RE: Taos II @ The Trails

Grading Plan

Stamp Date 1/11/2017 (File:C09D001G)

Grading and Drainage Plan & Report Stamp Date 7-13-16 (File:C09D00G1)

TAOS II AT THE TRAILS GRADING PLAN

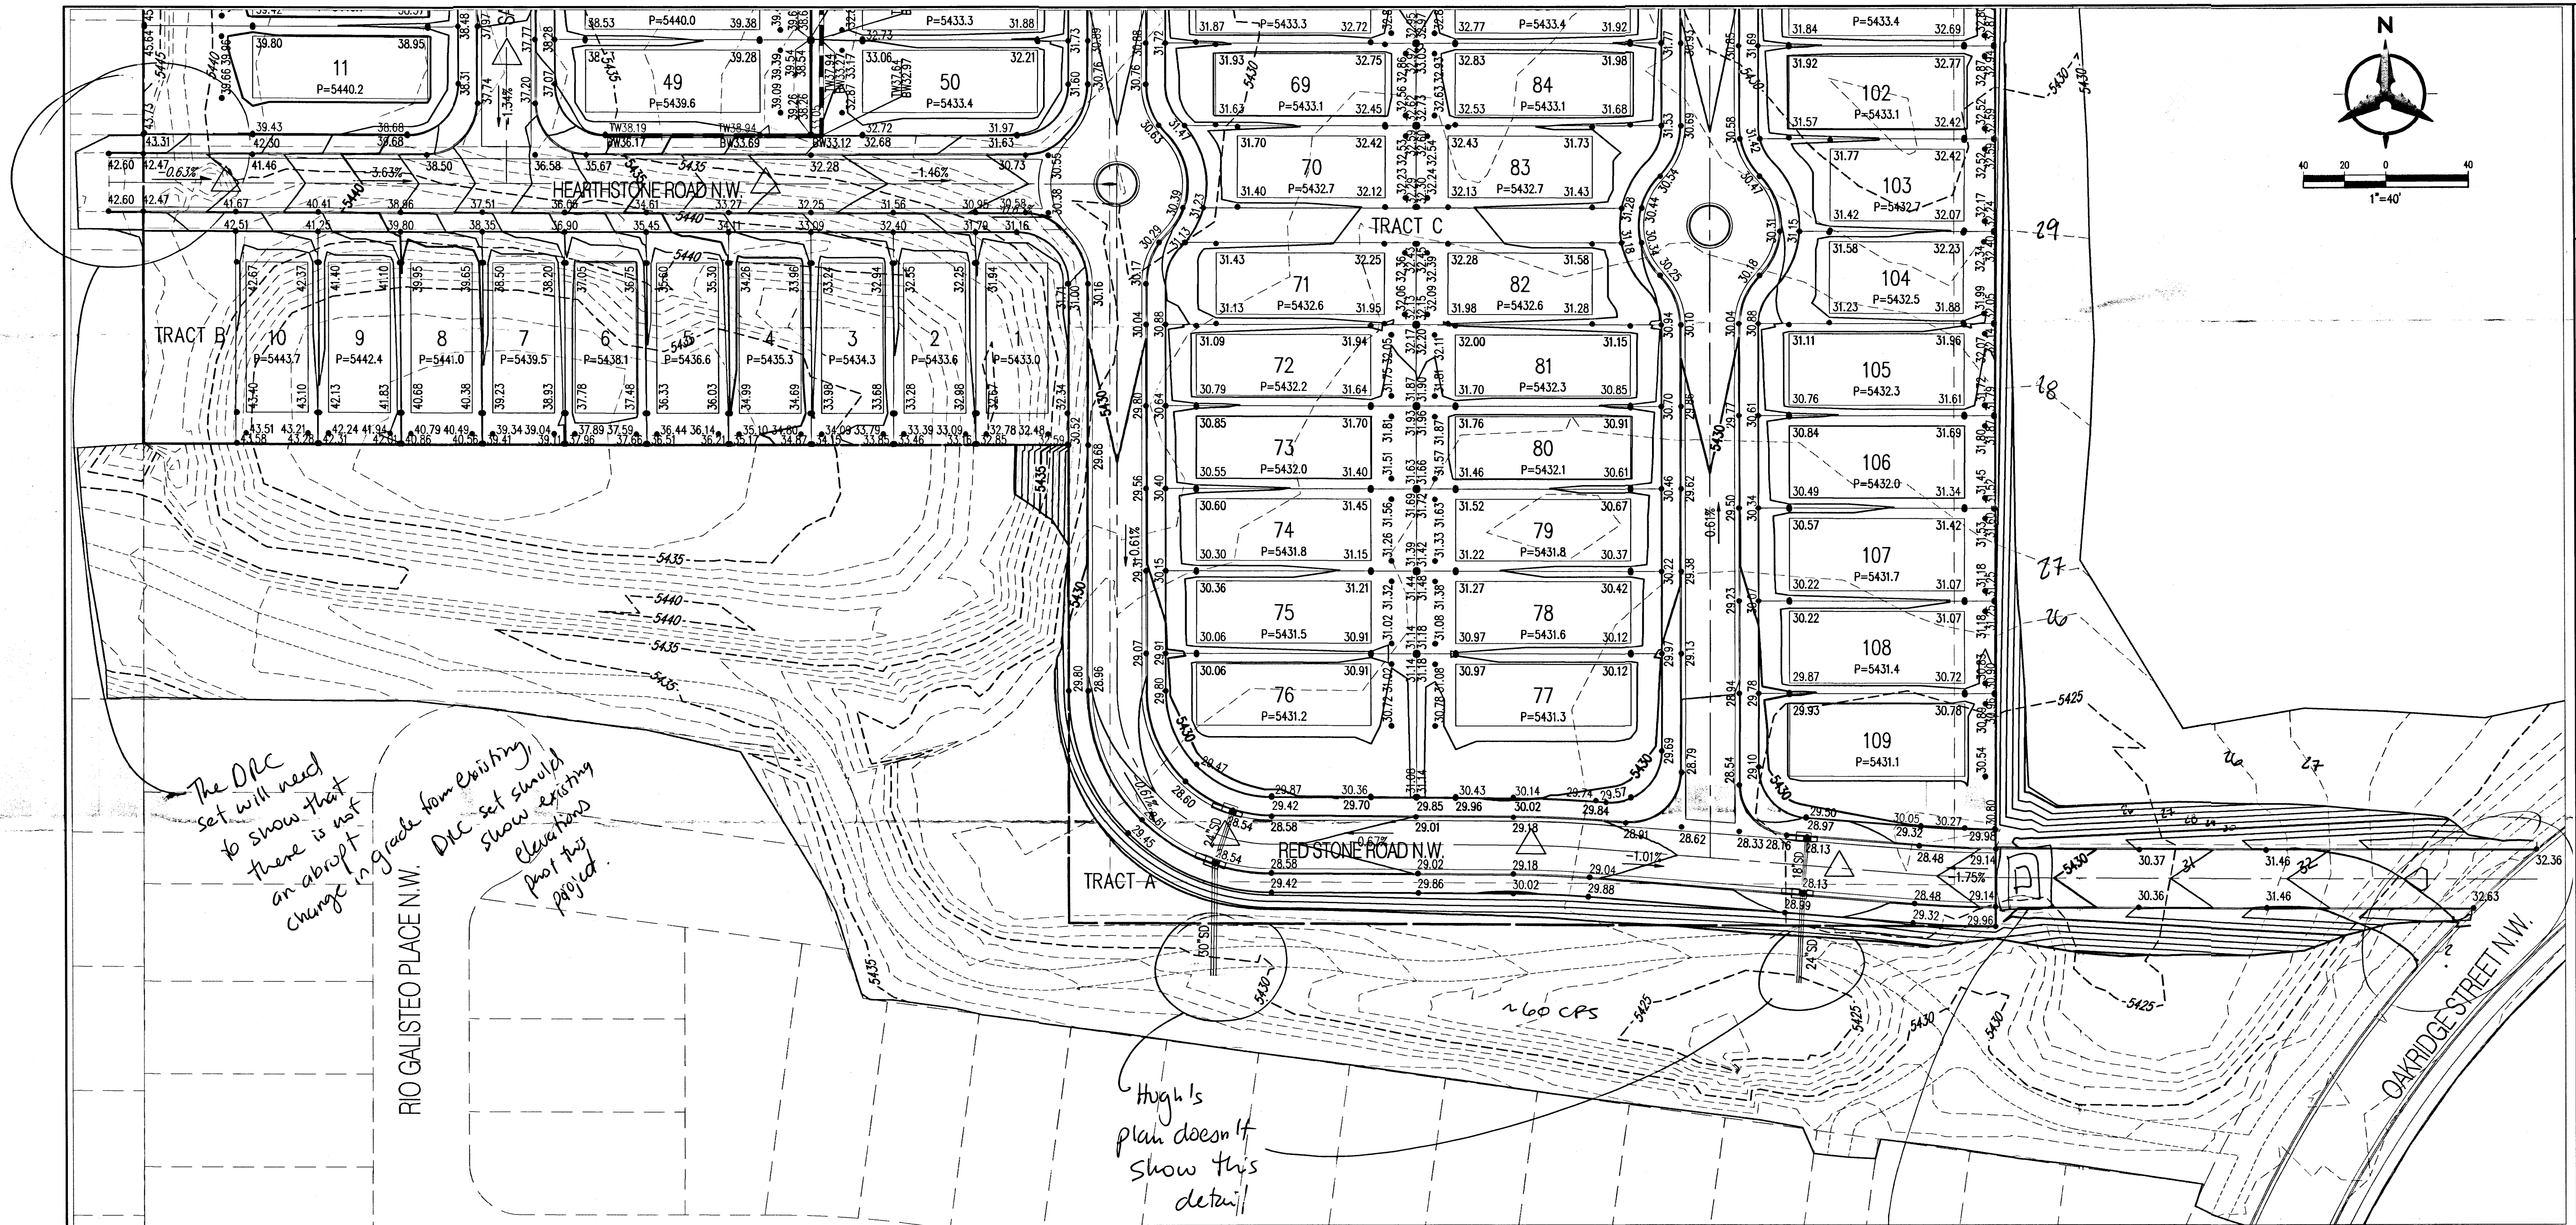
- 2. 2a and 2b. I don't see how these were addressed on sheet 1 or 2, hopefully they're addressed on sheet 3 with a detail dwg and notes For Ponds D and F5 the pond outfall risers are called out on the Sheet 2 of the grading plan and the riser details are shown in the construction plans (Sheet 21) since they are integrated w/the storm drain construction. We had to make minor changes to the Pond F5 riser. I have attached Sheet 21 w/the revised riser detail, which matches Sheet 2 of the grading plan that was submitted electronically this morning.

- 2. The improvements referenced on the Infrastructure List need to be shown on the Grading Plan:
 - a. The Improvements related to Ponds F, F5 and D. The orifice plate can be included by reference or as a specific note/exhibit of the improvements required.
 - b. The outfall conditions into Pond F5. Note that the Drainage Master Plan elevations are based on NGVD 29 datum.
- 3. It is not clear where the wall drain detail will be used since it appears that all lots drain to the roadway. Any planned rear-lot ponding would require an easement.
- 4. An approved ESC Plan will be required.
